DE-2018/215

STATE SIGNIFICANT DEVELOPMENT – KEMBLA GRANGE RESOURCE RECOVERY FACILITY (SSD 5300 MOD 2) – RESPONSE TO NOTIFICATION OF MODIFICATION

Attachment A - Comments on Modification Request

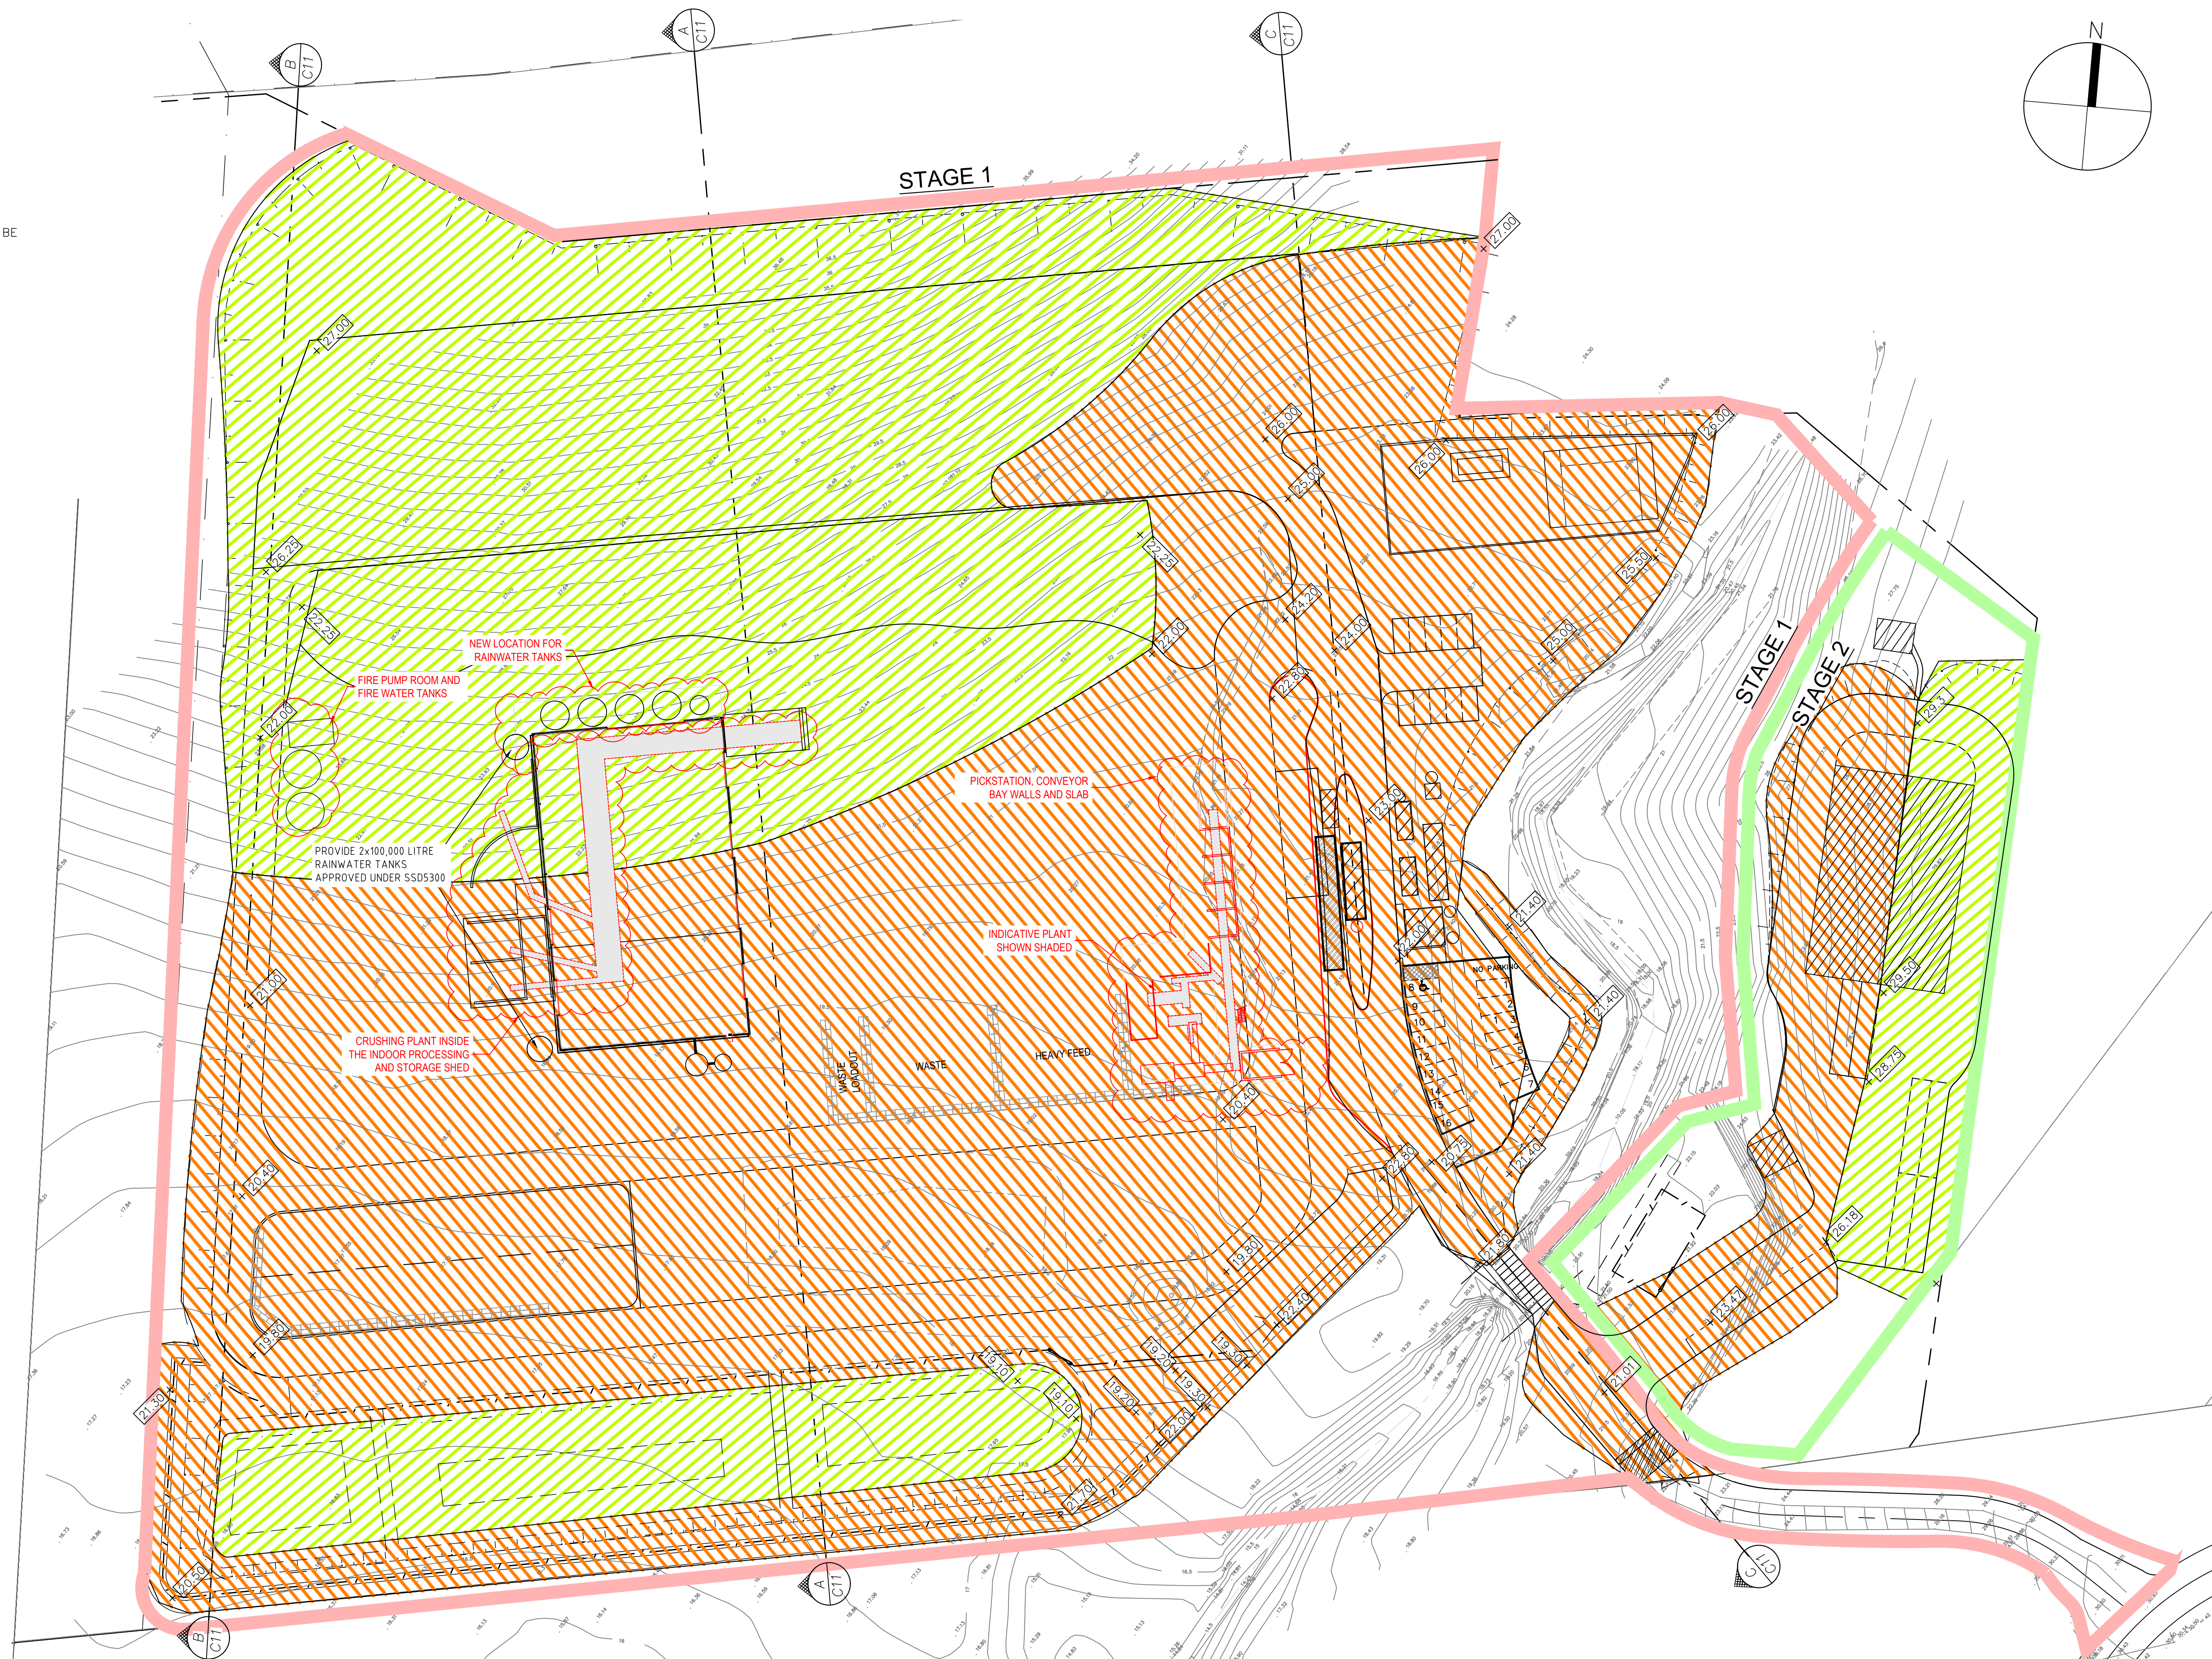
The ‘Blown Material Cage’ associated with the outdoor picking station appears to interact with the turning movements and site access arrangement for the site. The location of the proposed “Blown Material Cage’ or any other proposed facility should not impact on site manoeuvring for the existing approved uses. Reference is made to Drawing C18, Revision I, dated 25 October 2018 of the KFW plan set.
